**KIRKLEES METROPOLITAN COUNCIL
INVESTMENT & REGENERATION SERVICE**

DELEGATED DECISION TO DETERMINE PLANNING APPLICATIONS

Reference No:	2023/62/90814/E
Site Address:	50, Cornfield, Dewsbury Moor, Dewsbury, WF13 3UY
Description:	Erection of two storey side and single storey rear extensions and alterations
Recommending Officer:	Edward Cheseldine

DECISION - REFUSED

Project
50, Cornfield
Dewsbury, WF13 3UY
Drawing title
Proposed Block Plan

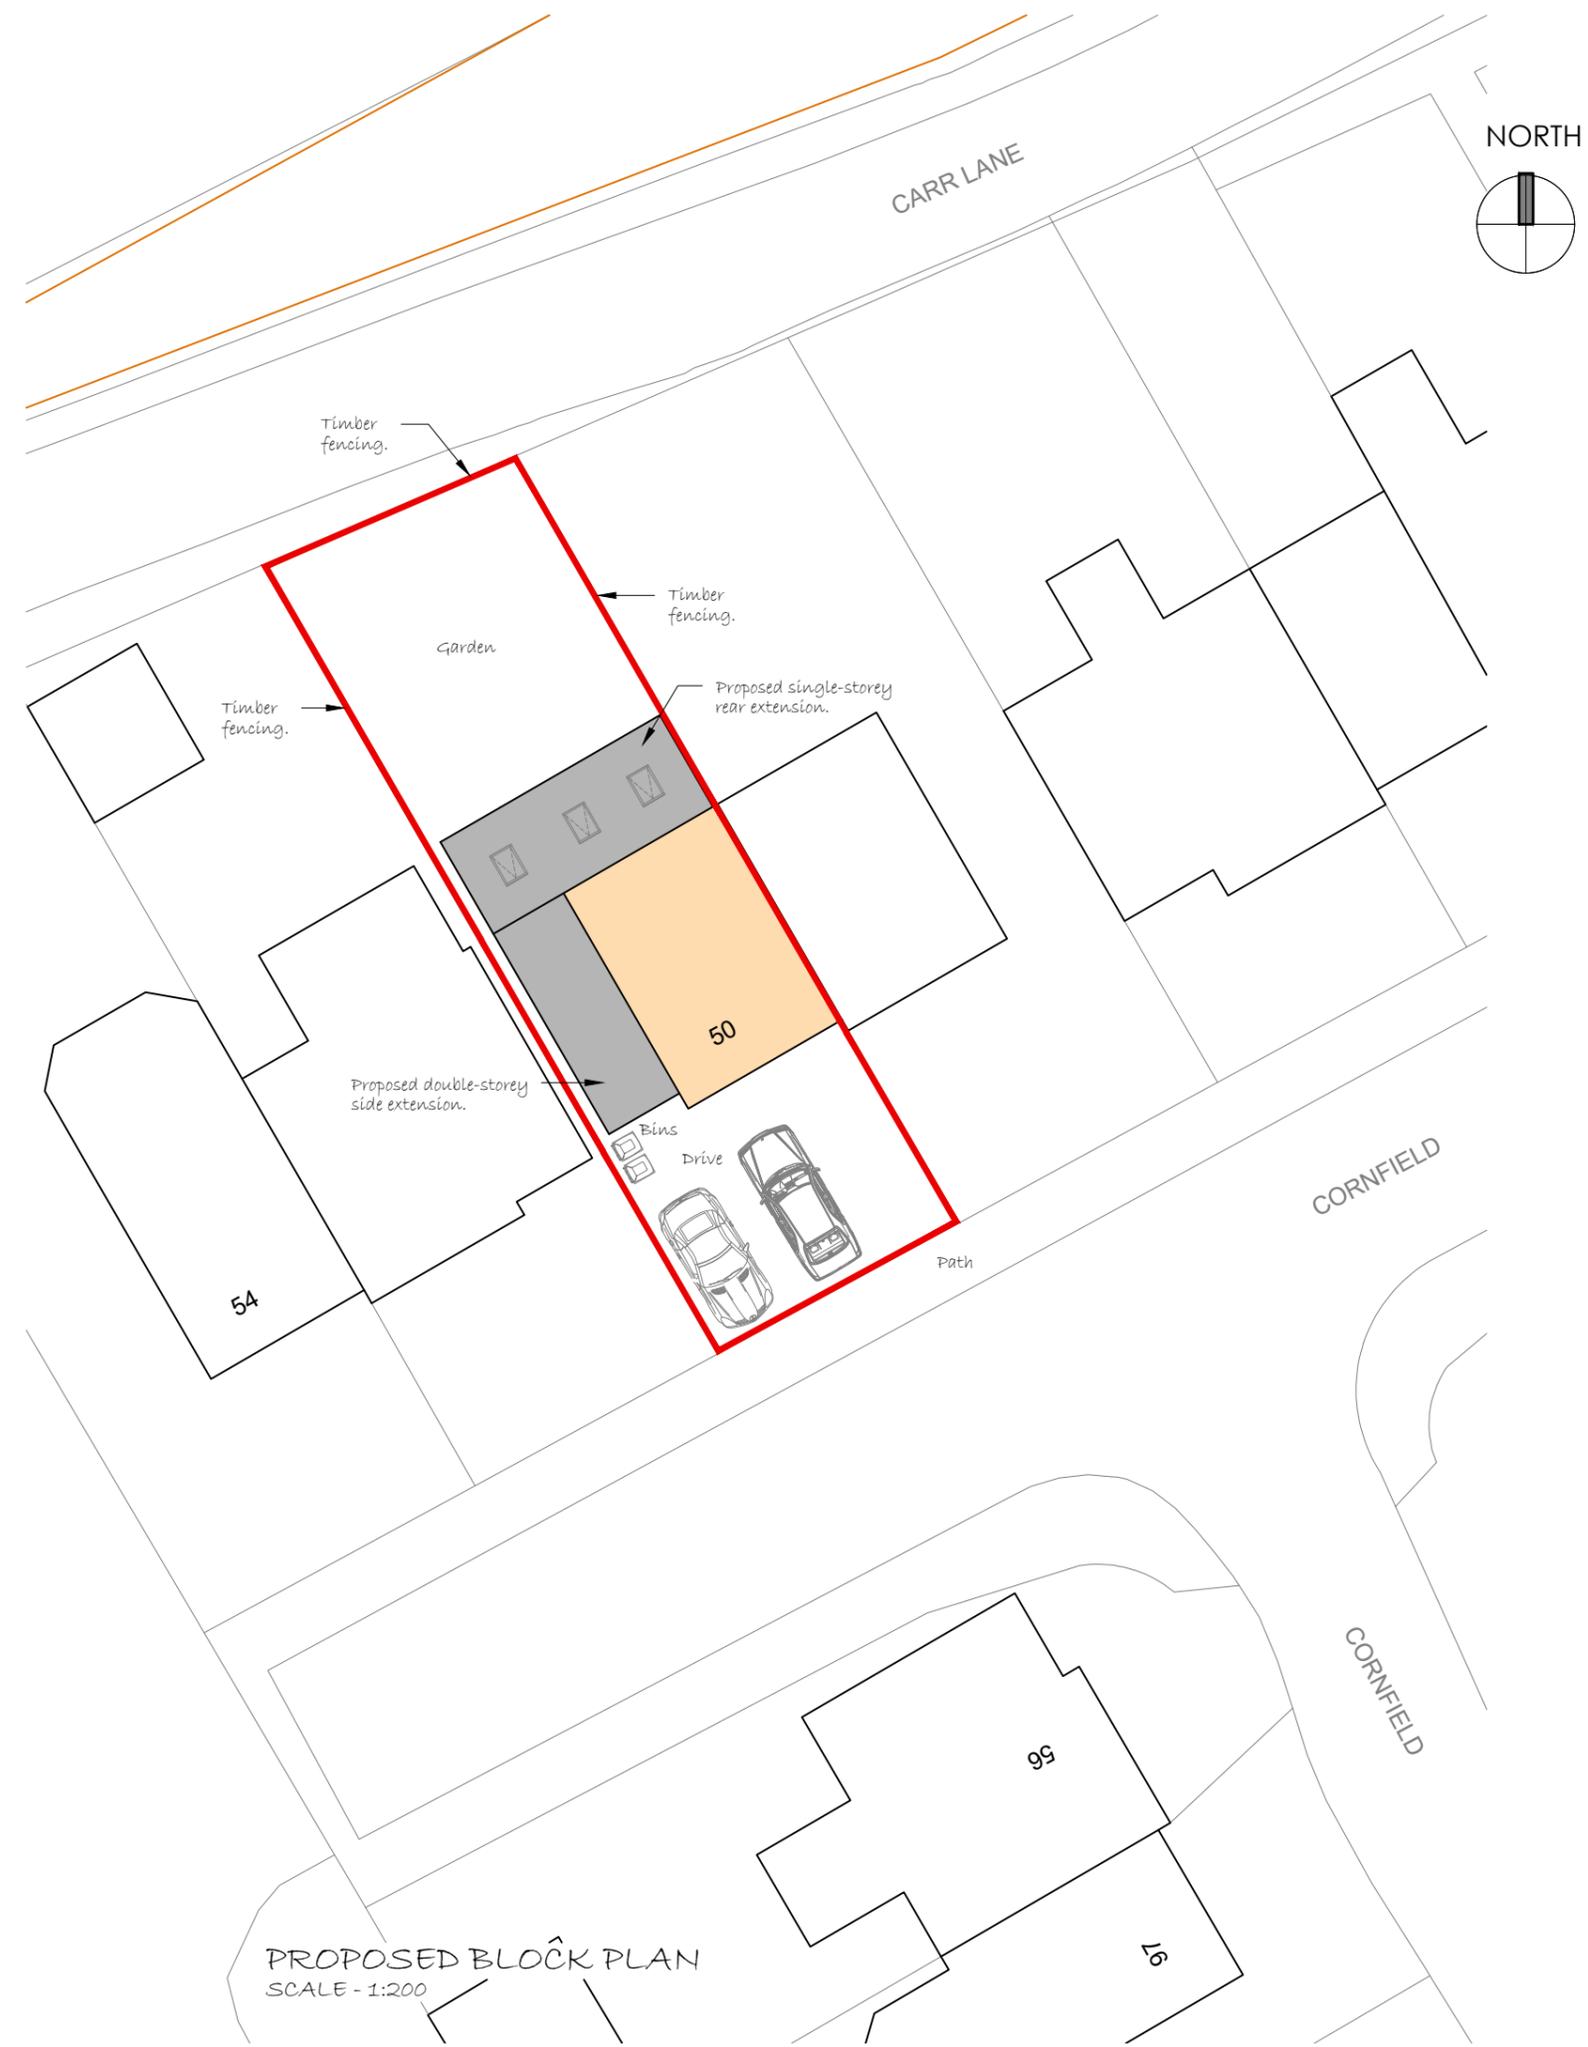
The proposal is to add additional living space, including one bedroom to the three-bed dwelling. This will intensify habitable accommodation which could cause additional demand to parking provisions. Currently there are two spaces on the existing drive. Plans show an addition space to be situated to the front of the property where there is currently outdoor green landscape, to mitigate the parking space lost due to the extension. A change in landscaping would alter the characteristics of the street, however other sites have created similar parking spaces and it would appear the works would still maintain some area of front garden, therefore the provision of the additional onsite parking bay is acceptable.

Side access will not be wide enough to allow for bins to be stored at the rear to the back outdoor space. Bin storage will be to the front and should be discreetly screened to prevent any loss of visual amenity within the streetscene. A condition requiring screening to mitigate the visual impact would be required or plans to demonstrate.

Drawing title  
Proposed Floor Plans  
and Roof Plan

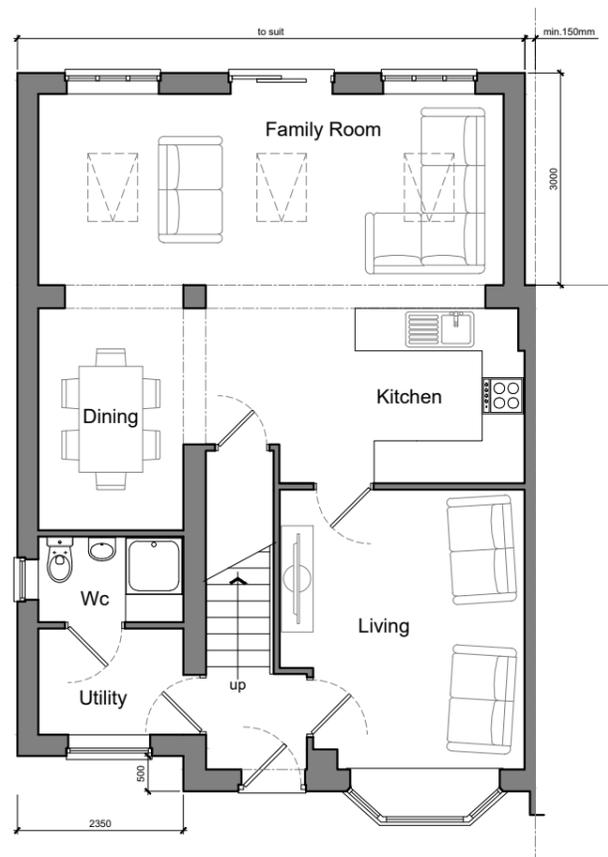
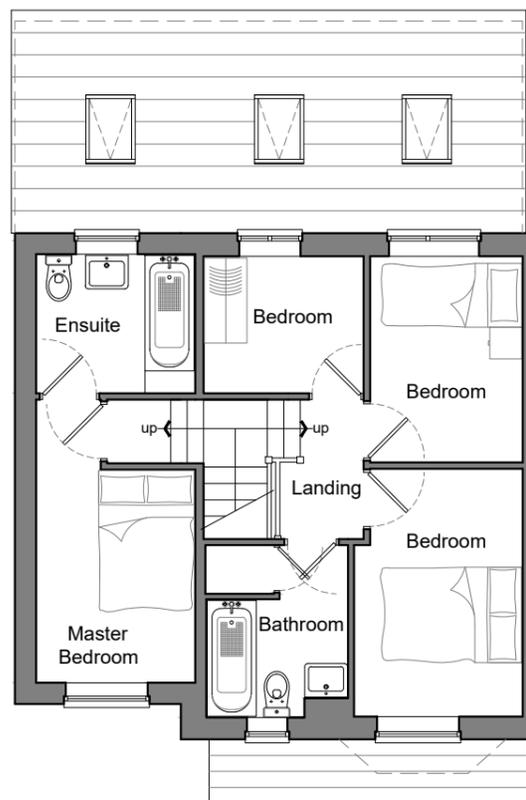
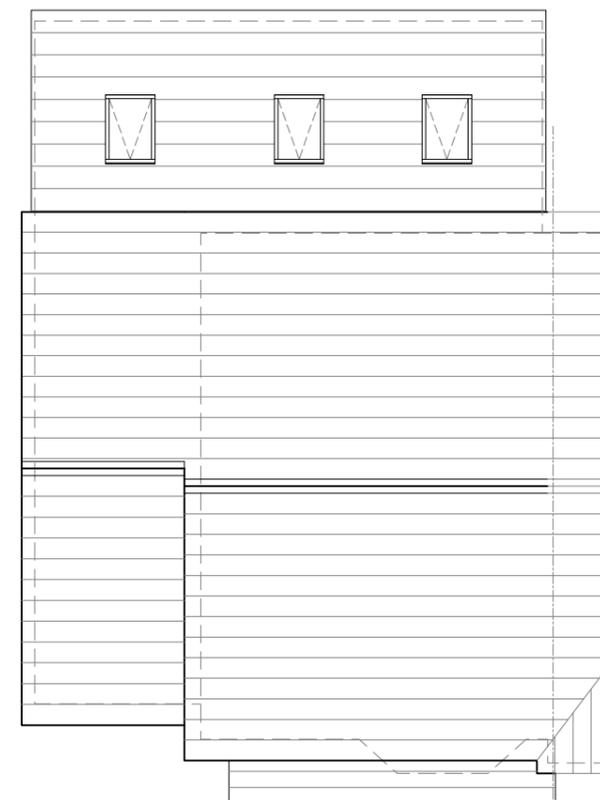
The side extension would project 2.35m, taking up the majority of the existing space to the side of the house. A minimal gap between the extension and property boundary will be left which measures 0.45m. The extension is set back from the front wall of the house by 0.5m. Additionally, the extension is set down appearing subservient to the original dwelling. Accumulatively, the side extension would not be compliant when considered against paragraph 5.20 of

the House Extensions and Alterations SPD in terms of projection. Furthermore, the extension does not retain an adequate gap to each boundary.

Whilst the extension is set back from the front elevation by 0.5m providing a visual break from a continuous property line, the distance between the side extension and property boundary would still be too small not thereby maintaining adequate space and not sufficiently mitigating a terracing effect. A 0.30m gap to the property boundary is considerably less than the 1.0m gap required as set out at paragraph 5.20 of the House Extensions & Alterations SPD. The lack of a visual break does would result in a loss of character to the street.

Having considered the above factors, the proposed development would result in a significant, adverse impact upon the visual amenity of the streetscape and wider area due to the lack of space and retention of a 1.0m gap to the property boundary therefore not complying with Policy LP24 of the Kirklees Local Plan (a) of the Kirklees Local Plan and House Extensions & Alterations SPD and Paragraph 130 (b) of the National Planning Policy Framework.

The two-storey side extension by way of design, height and distance to the property boundary, would fail to retain a 1.0 metre gap to the side boundary thereby appearing cramped within the plot and would result in erode the space between the houses forming a terracing effect in the street scene, thereby not promoting good design. The development would be detrimental to visual amenity and character of the area and be contrary to Policy LP24 of the Kirklees Local Plan and paragraphs 4.1, 4.2, 4.3, 5.19, 5.20 & 5.21 of the Kirklees House Extensions Supplementary Planning Document as well as Chapter 12 of the National Planning Policy Framework.

Project
50, Cornfield
Dewsbury, WF13 3UY
Drawing title
Proposed Elevations

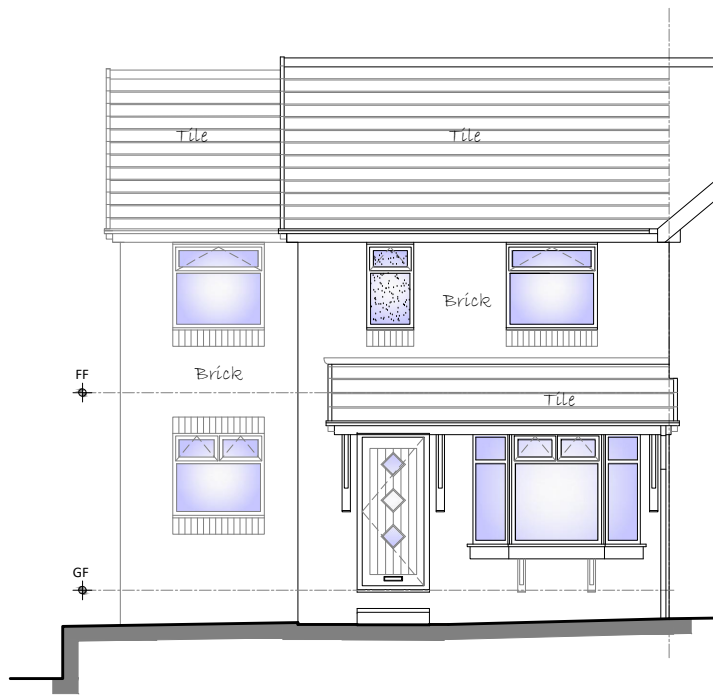
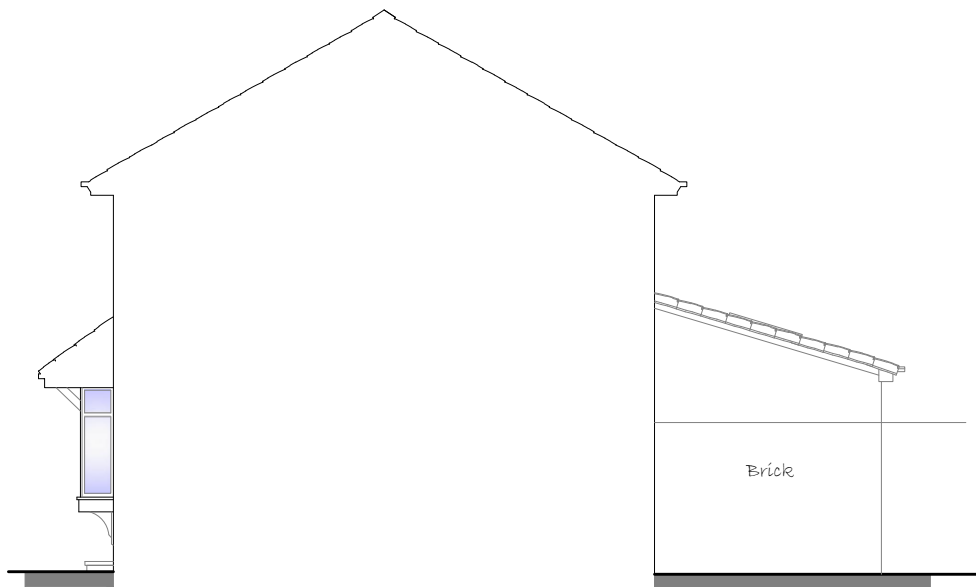
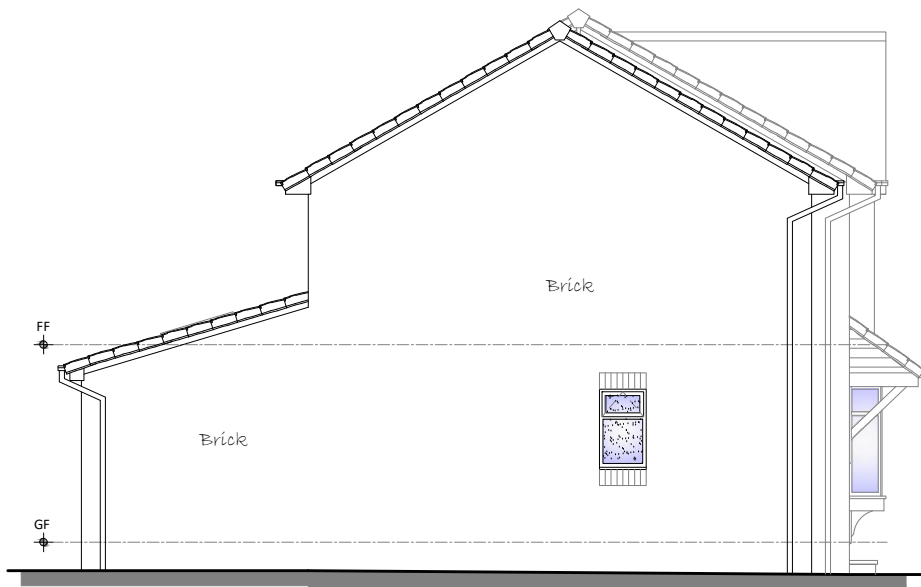
The side extension is to project 2.35m from the existing side elevation, to a length of 6.7m. The height of the side extension is to be 5.0m, matching the eaves of the existing house, reaching a total height of 7.3m to the ridgeline of the side extension. The extension is to be set back 0.5m and set down 0.2m.
